OBSERVATION/SUBMISSION TO PLANNING APPLICATION

Case Reference: 323761

Re: Observation/Submission to proposed wind energy development at Cooloo Wind Farm

Applicant: Neoen Renewables Ireland Limited

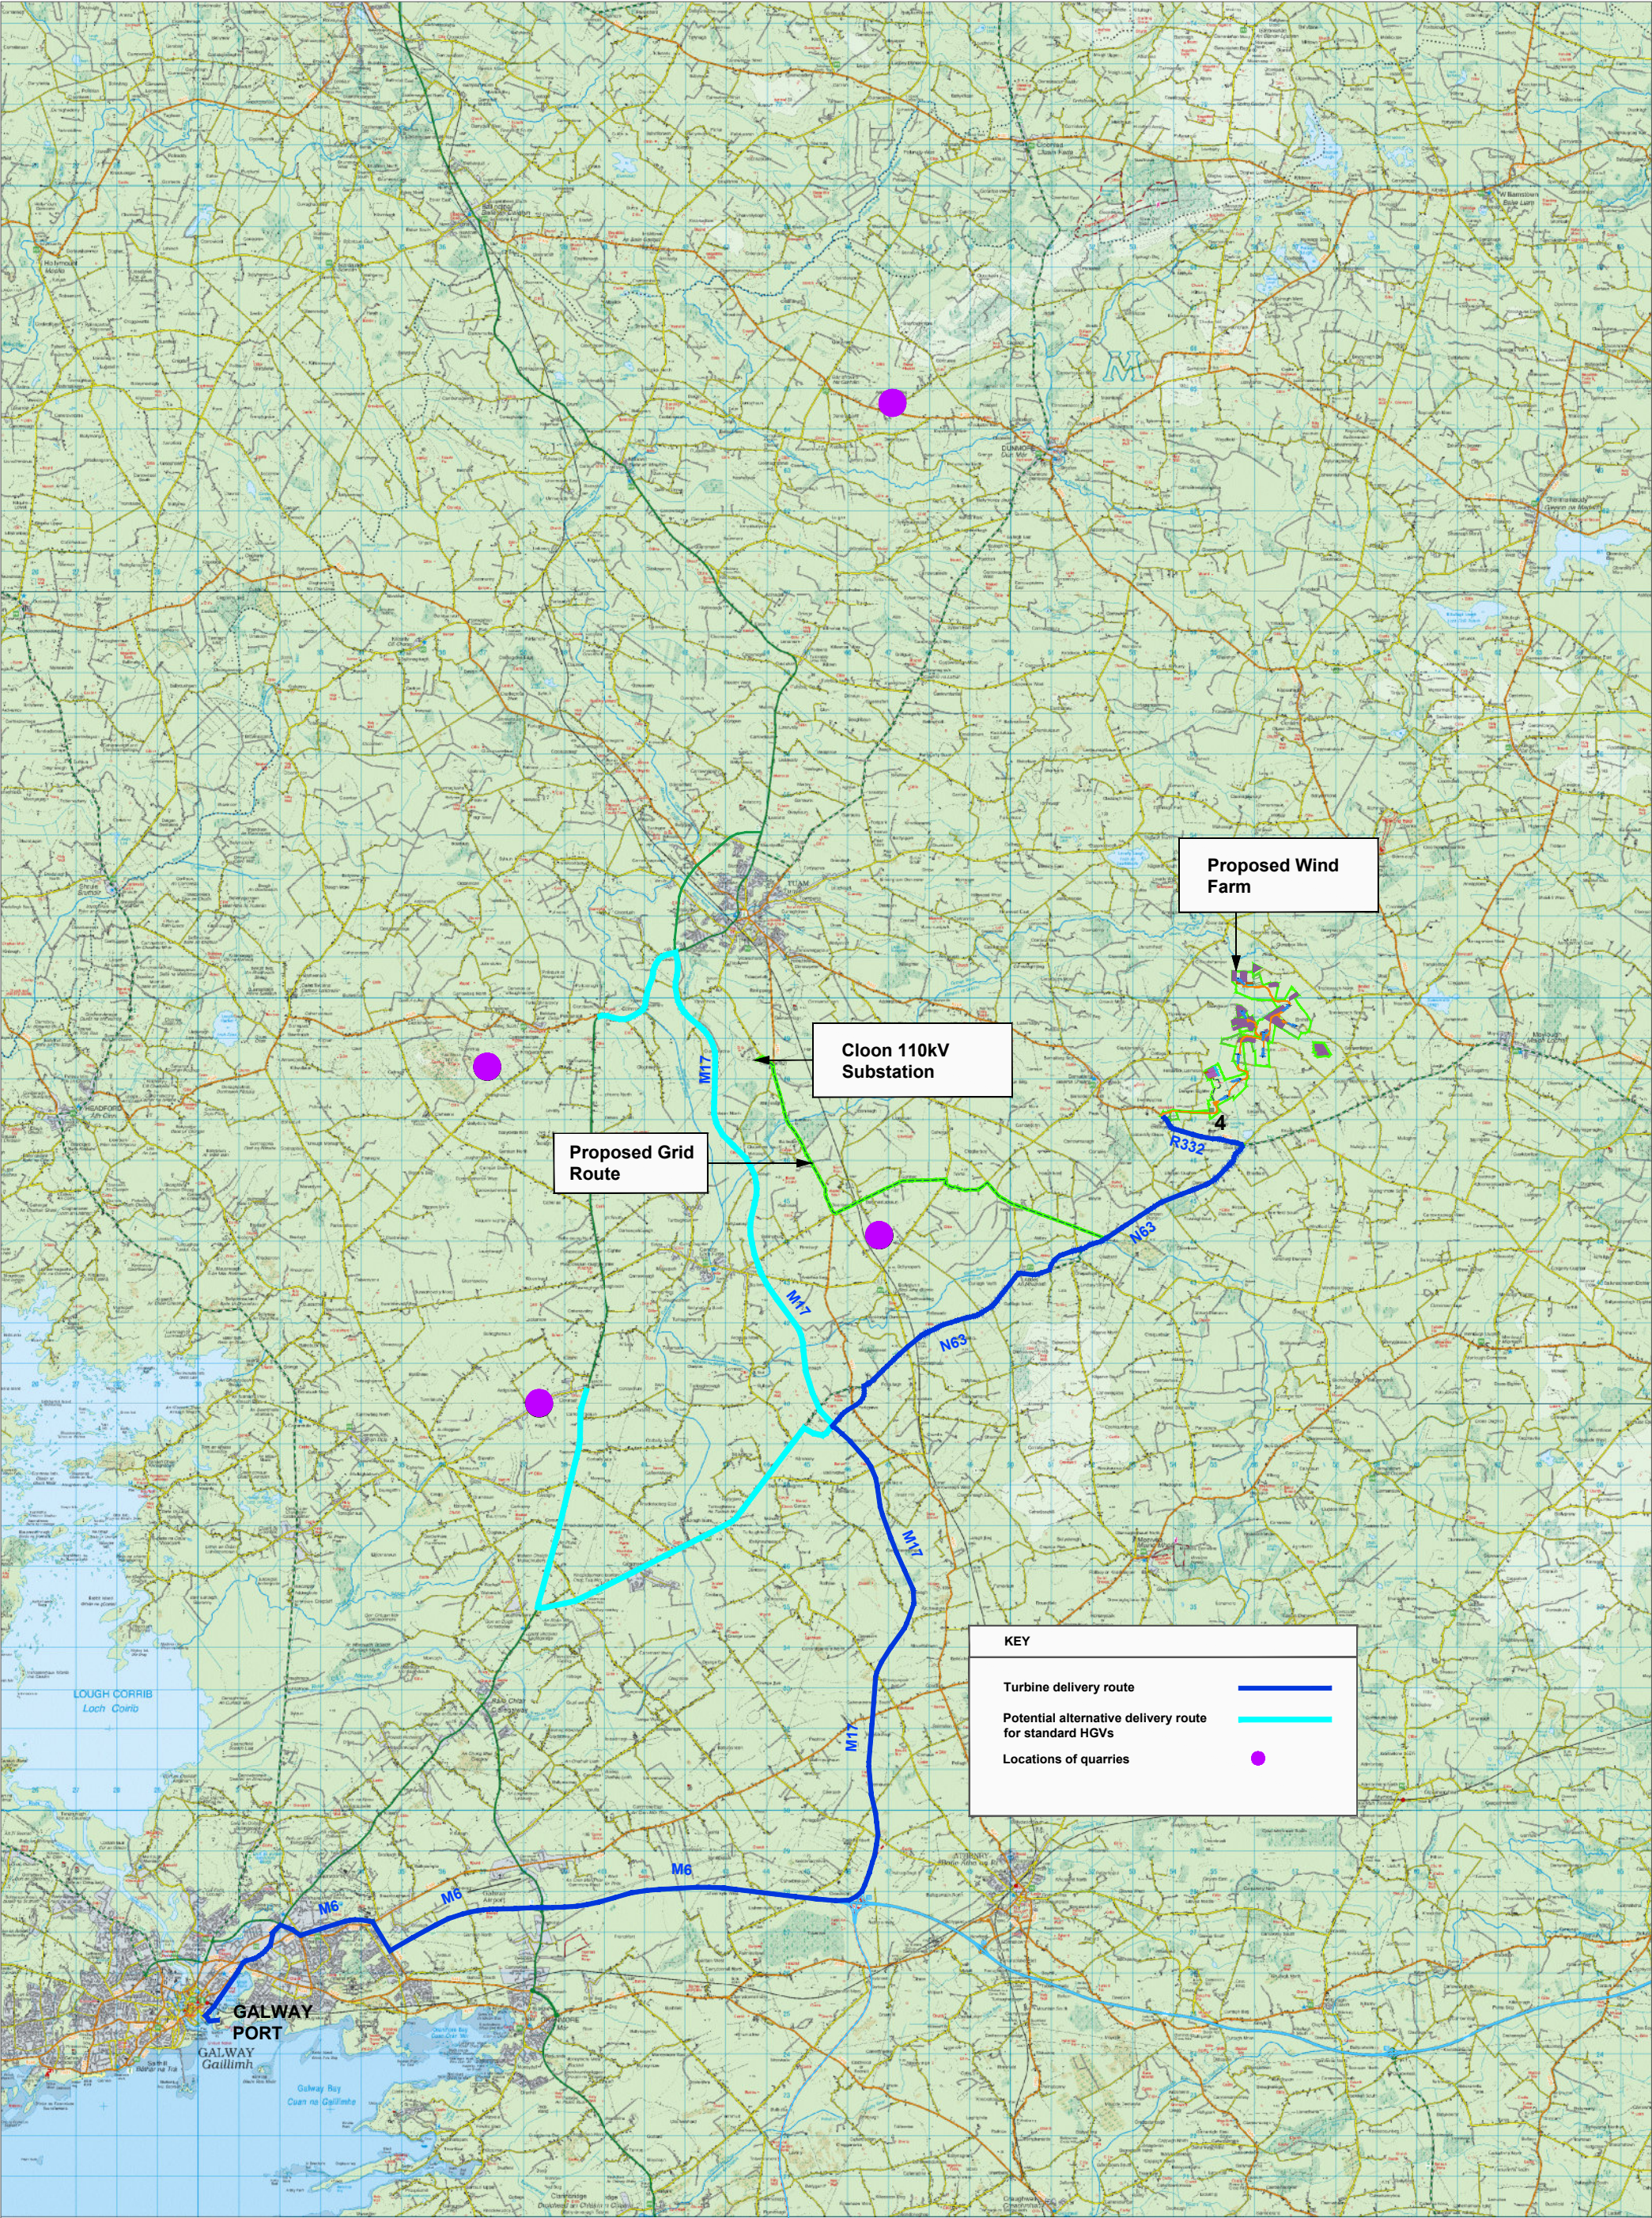
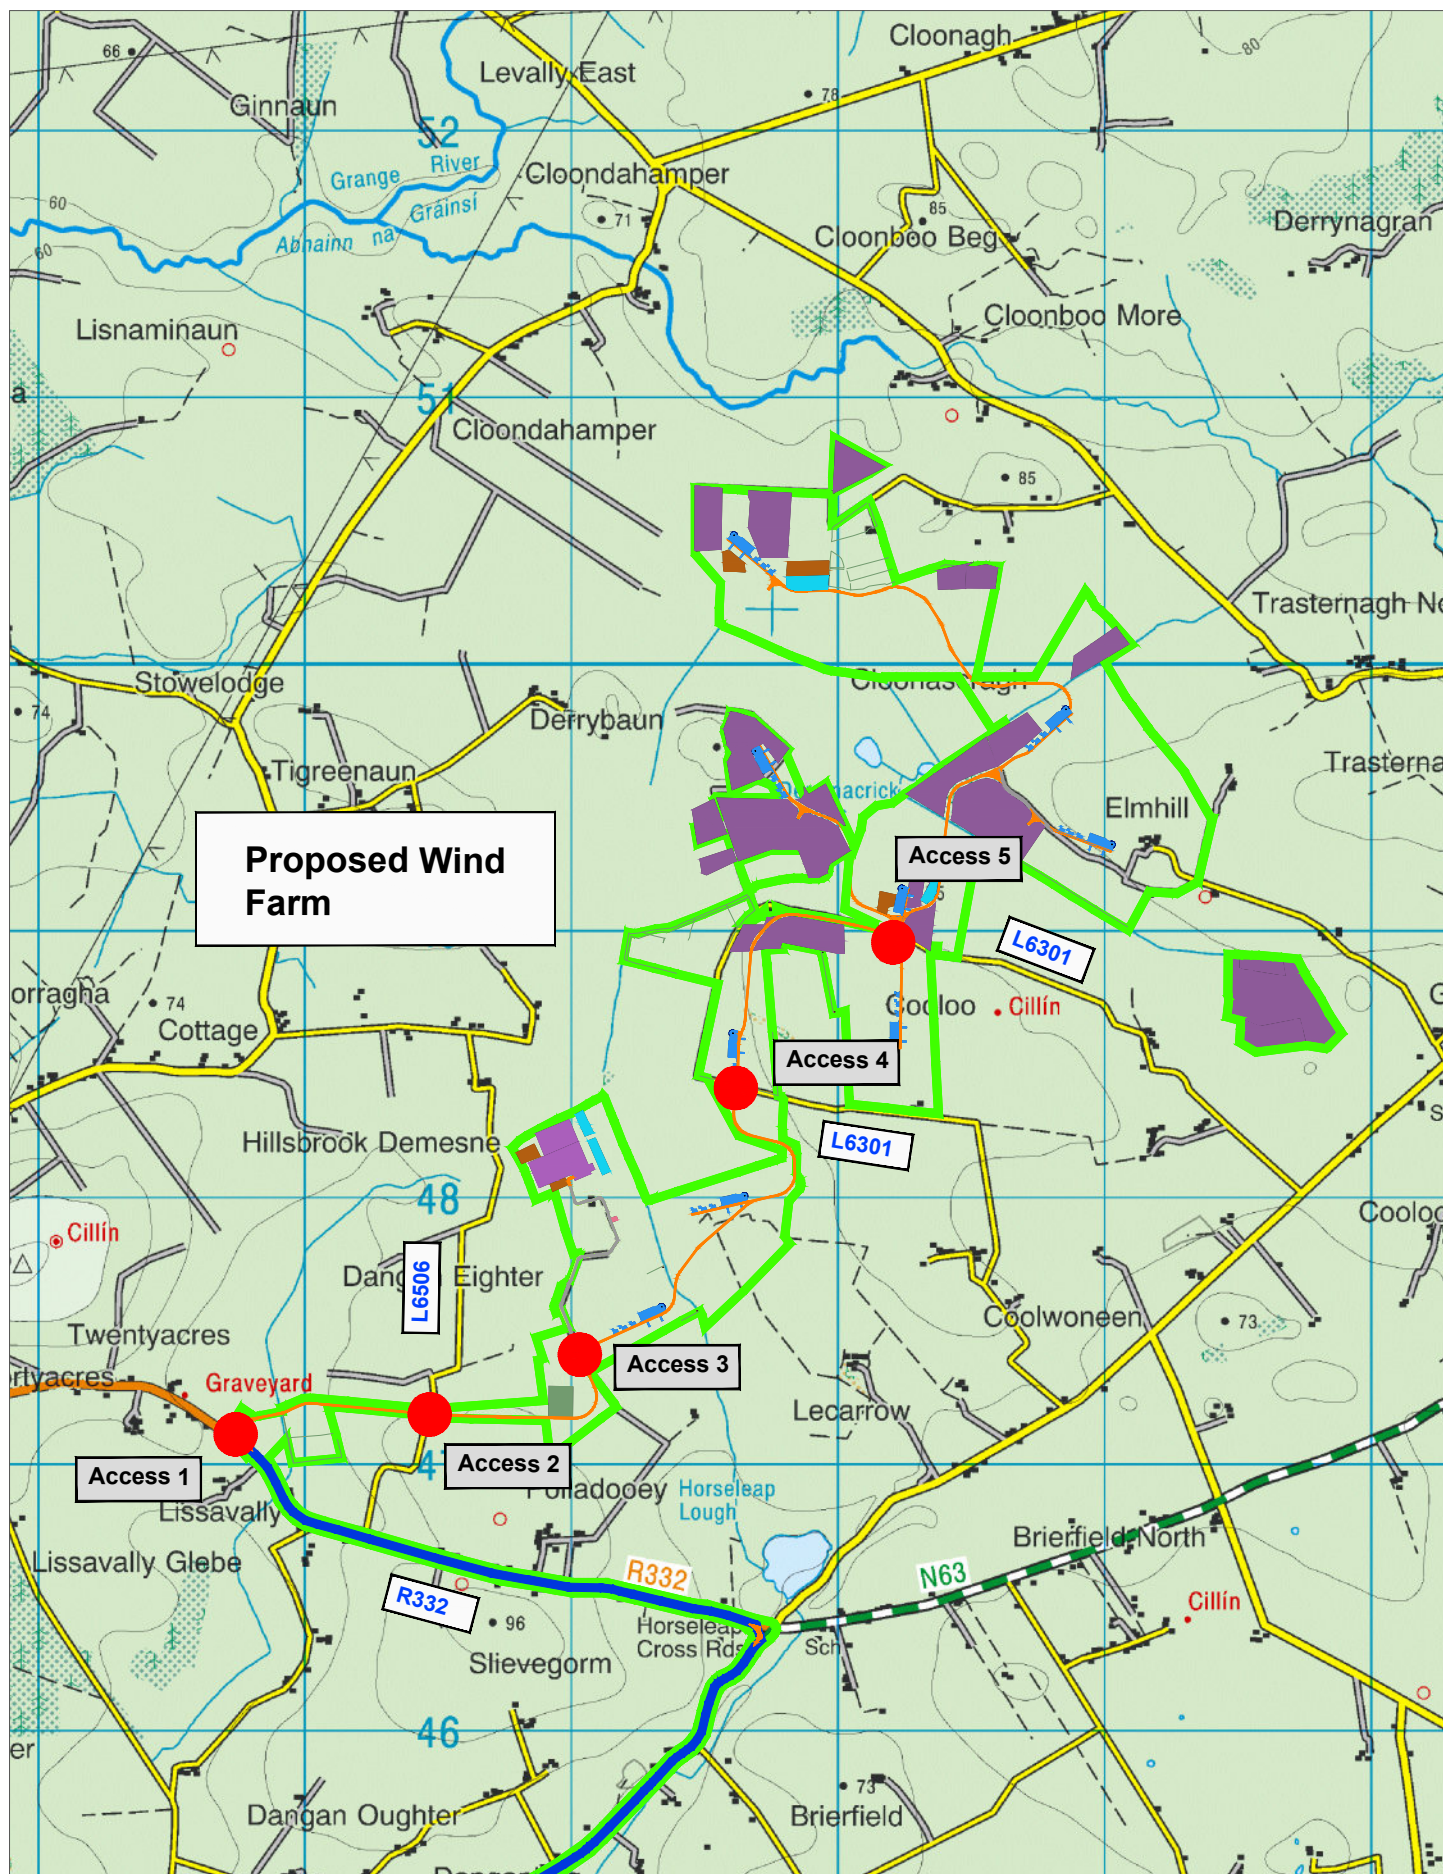
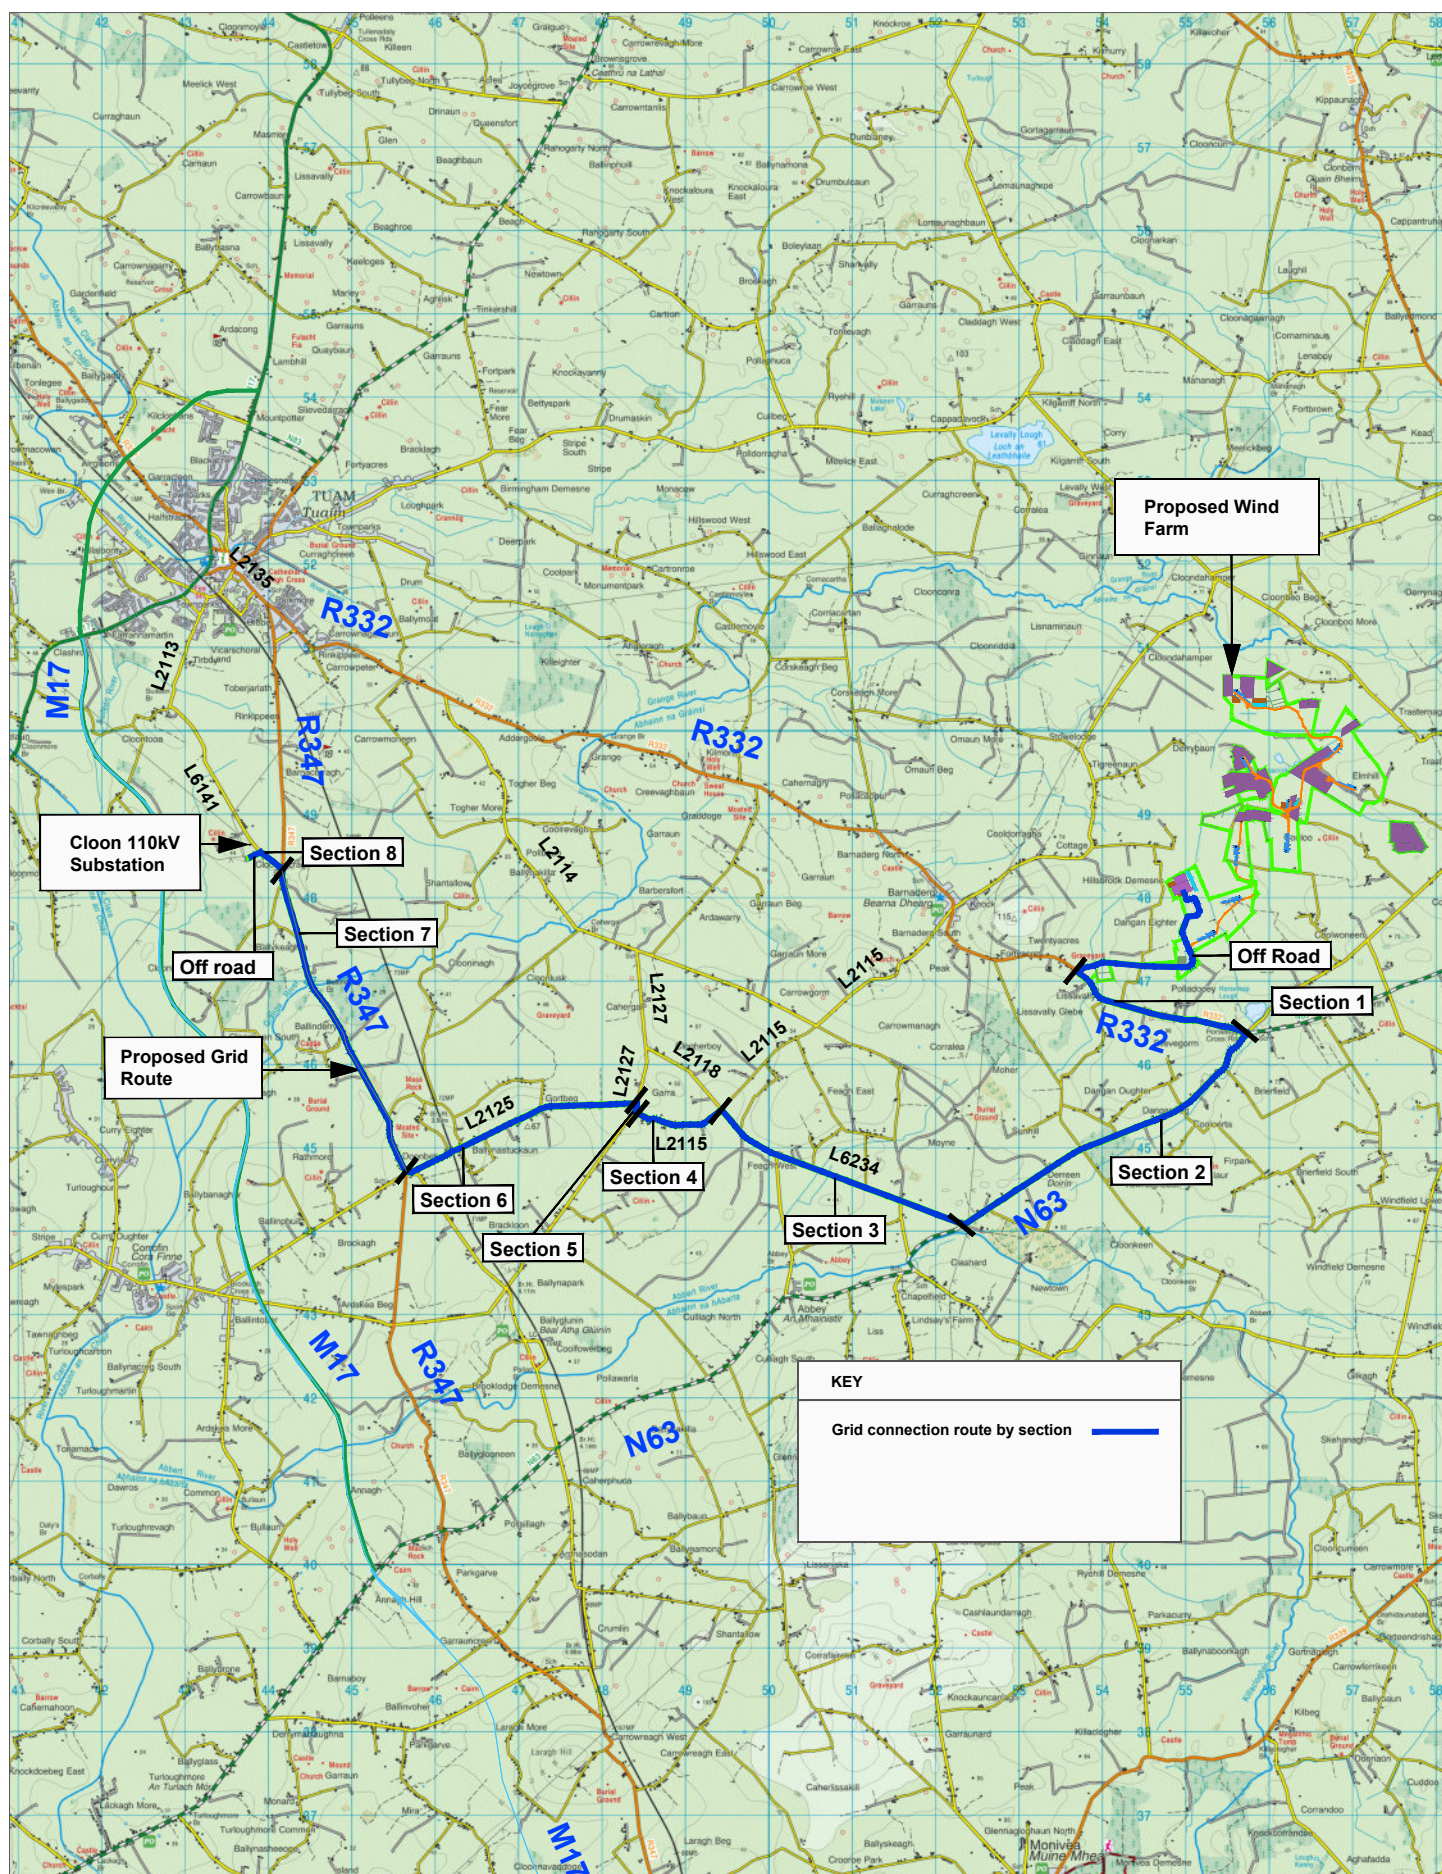
This submission objects to the proposed development due to insufficient traffic management and risk assessment in Appendix 15-2 (Traffic Management Plan). The plan omits essential quantitative data—such as expected abnormal load numbers, peak-phase traffic volumes, and route-specific scheduling—required to evaluate construction impacts. Narrow rural roads near Barnaderg and Cooloo lack the capacity for large turbine transport without pre-works strengthening or verge reinforcement. No detailed programme for road condition monitoring or reinstatement is provided. The TMP also fails to model cumulative or worst-case haulage scenarios, nor does it include enforceable mitigation measures for school transport, farm access or local business continuity. In the absence of these specifics, the project's potential impacts on road safety, infrastructure integrity and rural amenity remain unacceptably high. The application states that locals will kept informed about traffic construction. Judging by how poorly locals were informed about the windfarm initially, I would be very sceptical as to whether we would be kept informed once construction was to commence. The Board should refuse permission or impose strict, verifiable traffic and haulage conditions.
